DECISION DELEGATED TO DEVELOPMENT MANAGER

Application No: H11-0715-20 **Applicant:** Mr & Mrs R Simmons
Proposal: Proposed Extension
Location: 71 Roman Bank Long Sutton Spalding
Terminal Date: 27th October 2020

PROPOSED EXTENSION AT
71 ROMAN BANK, LONG
SUTTON
FOR
MR. & MRS. R. SIMMONS.
PLAN AS PROPOSED

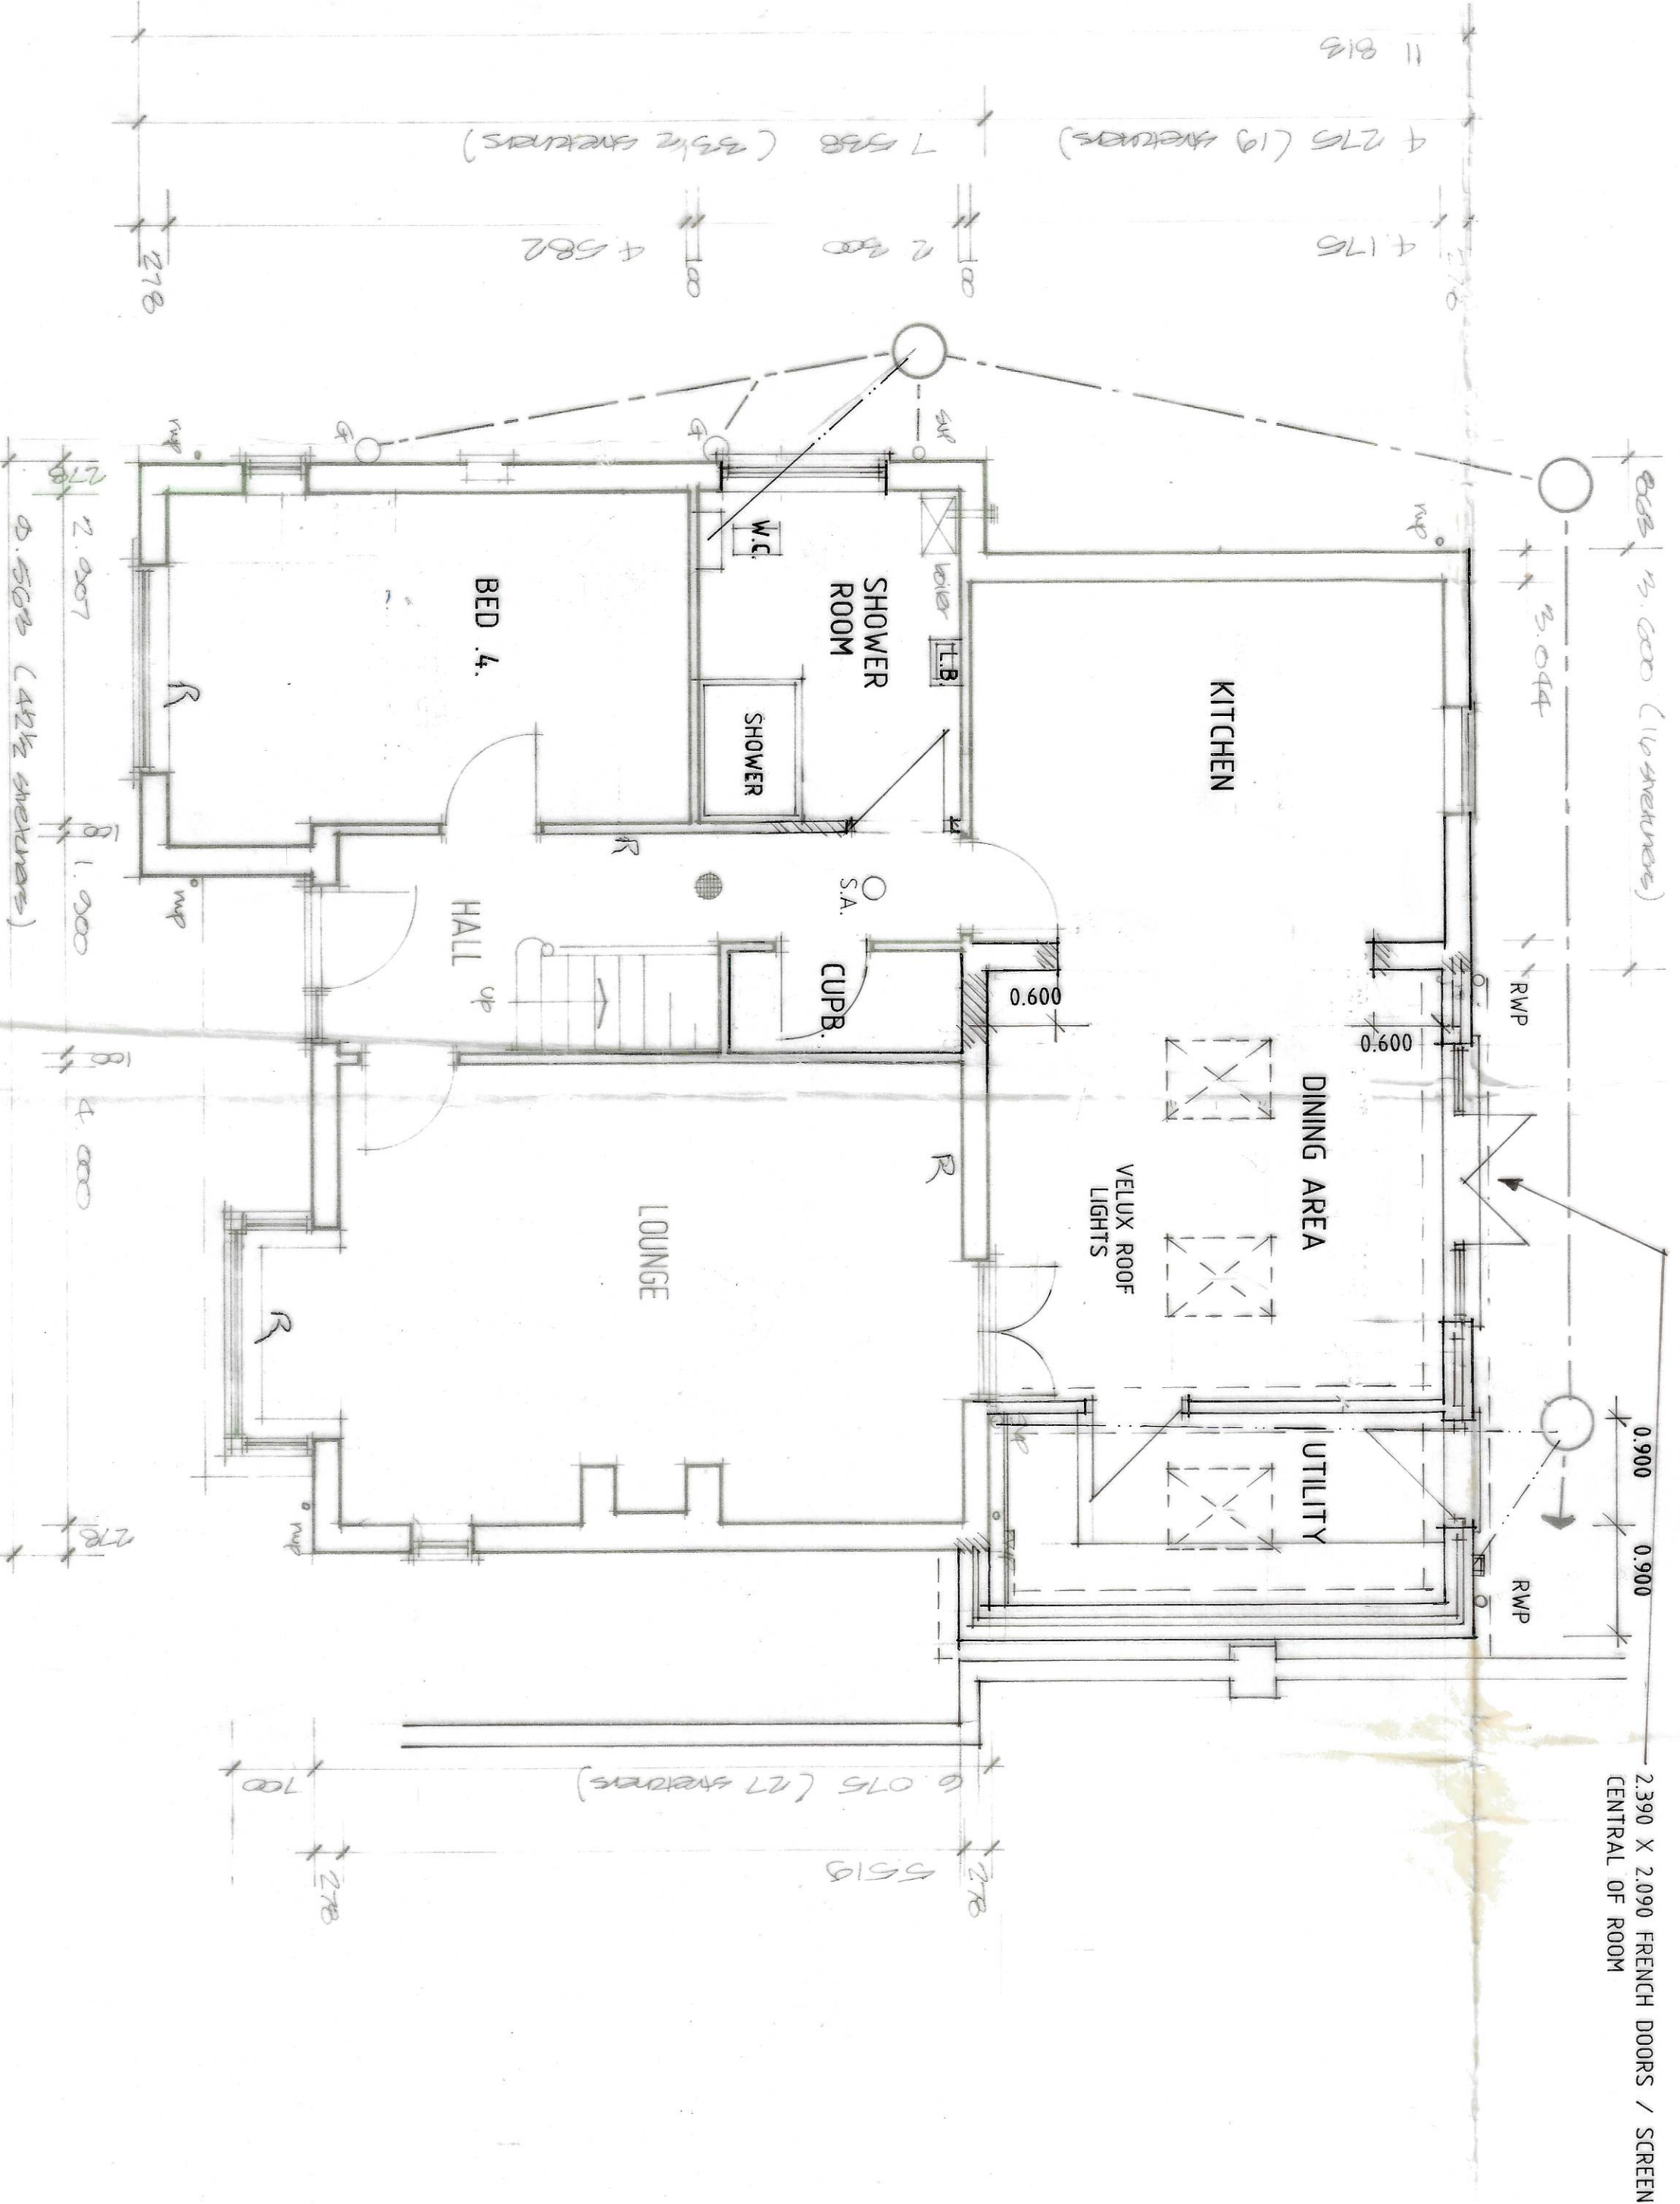
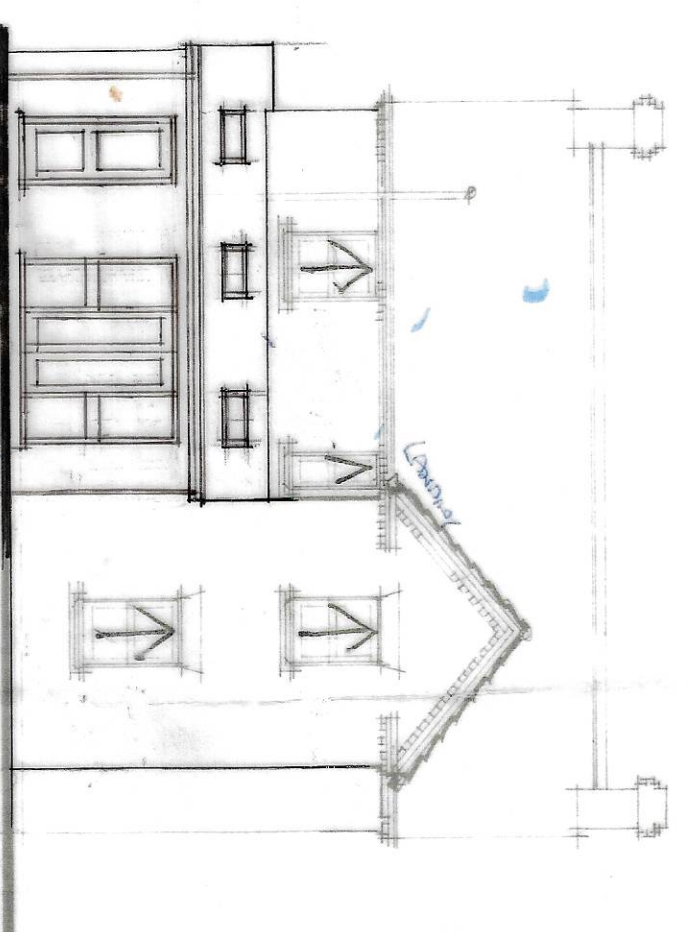
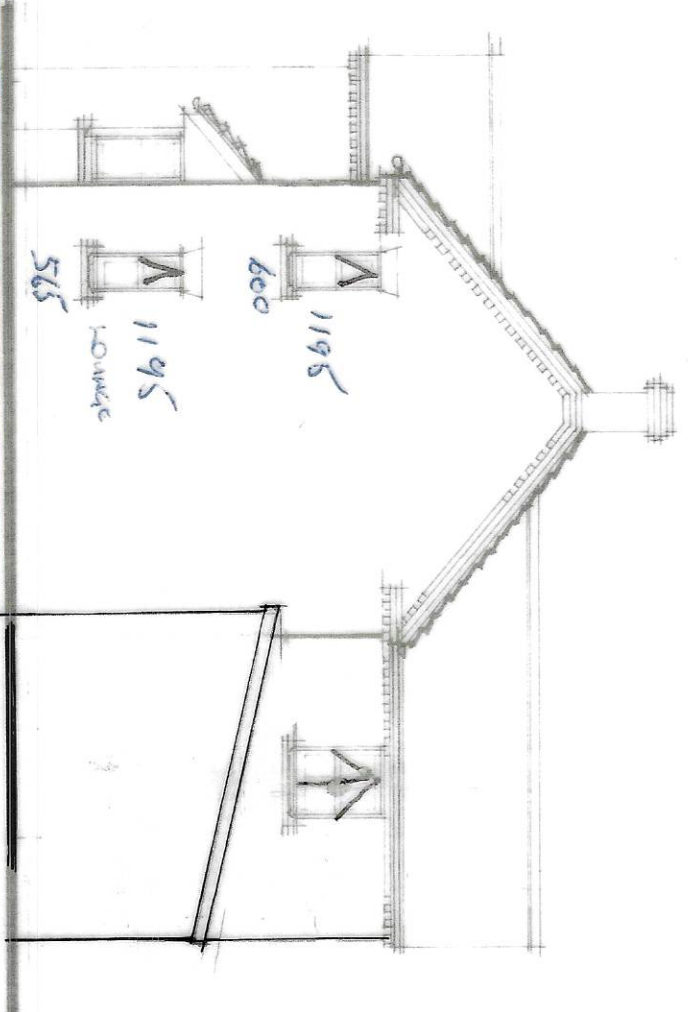
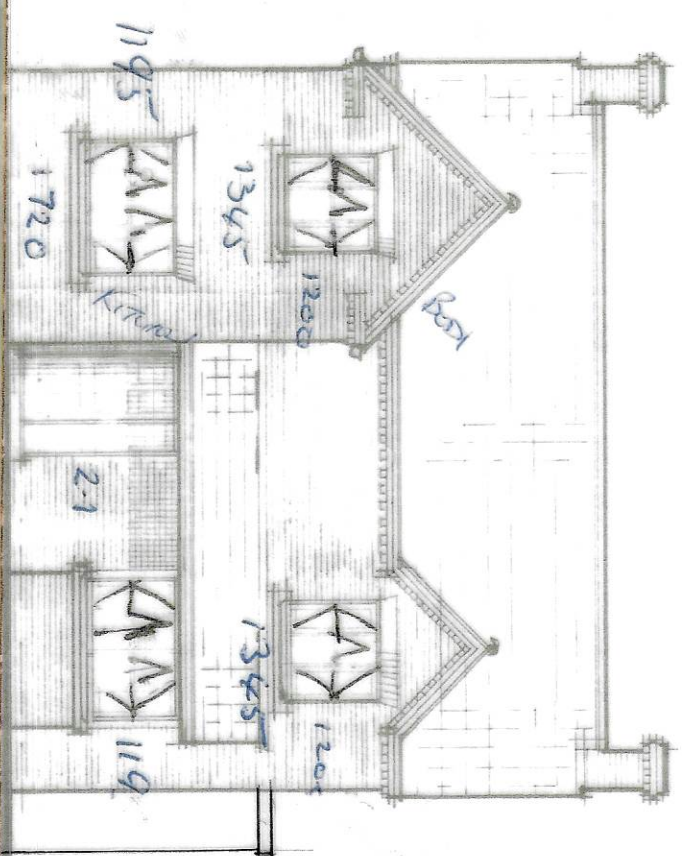
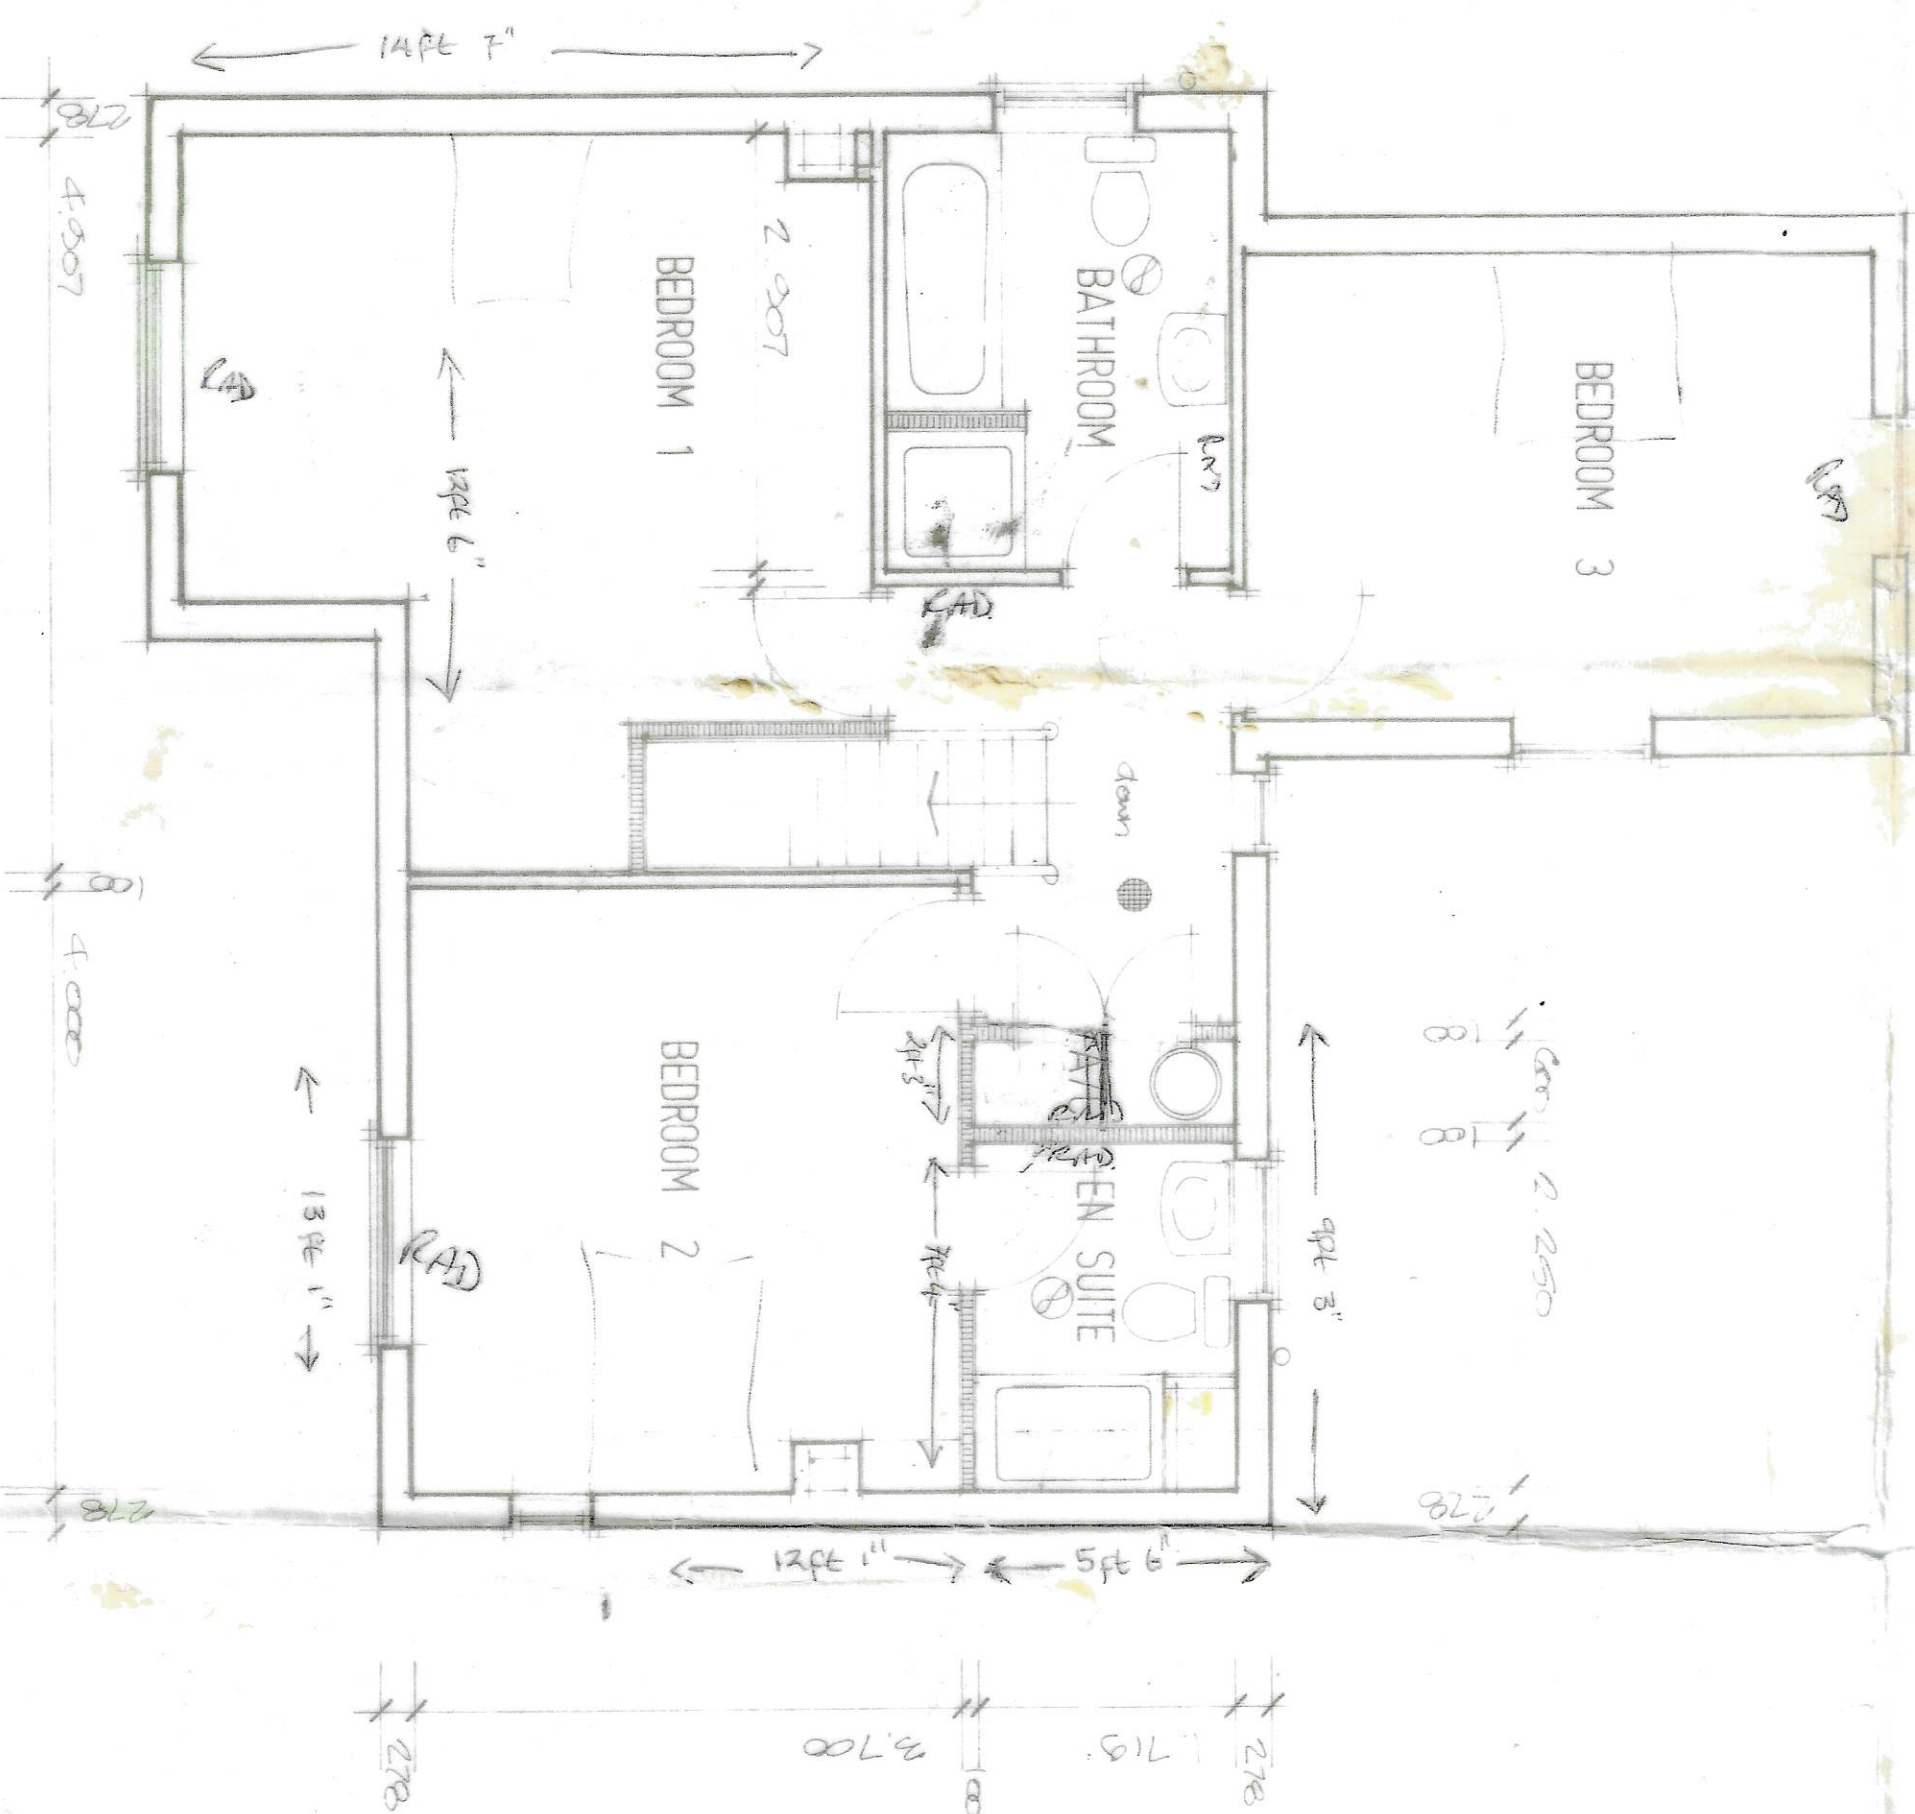
The proposed extension will protrude as much as the adjoining two-storey element which host the kitchen on the ground floor level. It will extend to the north protruding marginally 80 centimetres

from the northern wall of the house. The apex height will be approximately 3.53 metres and the eaves 2.35 metres high. Thus, the extension will be subservient to the host property by reason of dimensions.

A shed roof will be on top of the extension. This roof layout is deemed acceptable given the footprint of the extension. Visually, it relates well with the high gable pitches across the elevation of the building. French doors will be installed on the rear wall onto the garden and 3 no. Velux roof lights will be formed on the roof. Such fenestration will enhance the enjoyment of daylight for the house occupiers. One single panel door will be next to the French doors to give access to the utility room from the garden.

Facing brickwork including stone window cills will match the existing. Likewise, roof tiles will be Forticrete Centurion Autumn which will match those existing on the house roof. The rainwater goods to be UPVC as the existing albeit no colour defined. For these reasons, the material schedule will appear well blended with the house.

SECTION/SITE PLAN

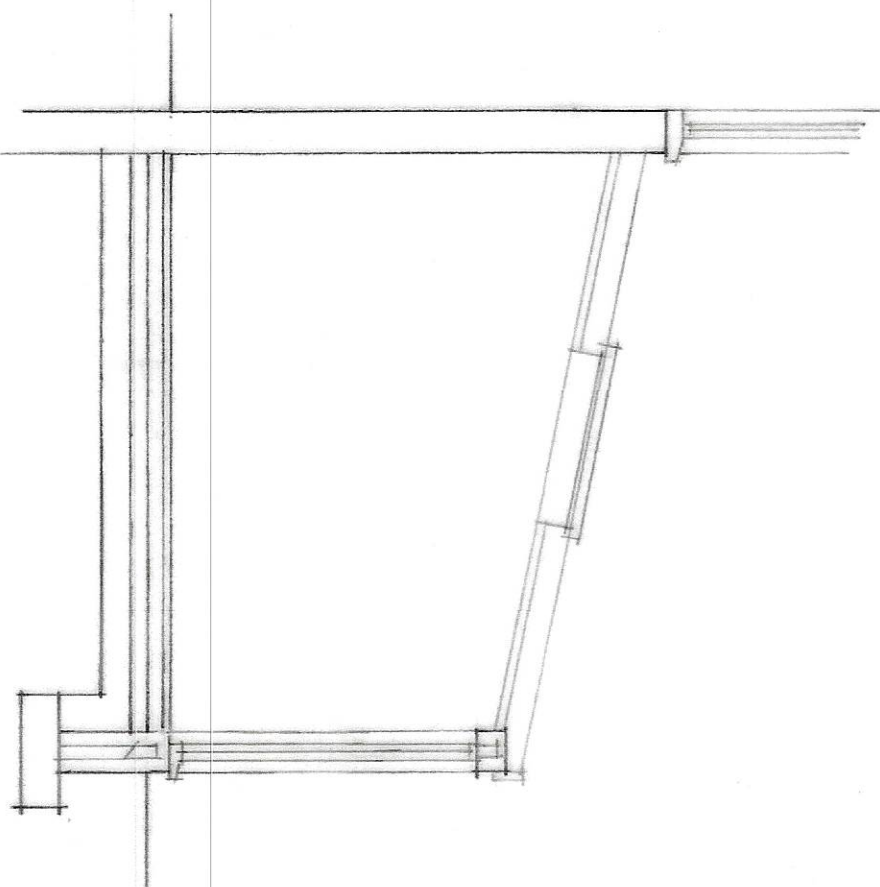
Pipes will convey surface water runoff from the extension roof to a soakaway sited 5000mm away from buildings. Foul water from the new shower room, kitchen and utility will be conveyed to the existing pipelines and eventually discharged into the main sewers.
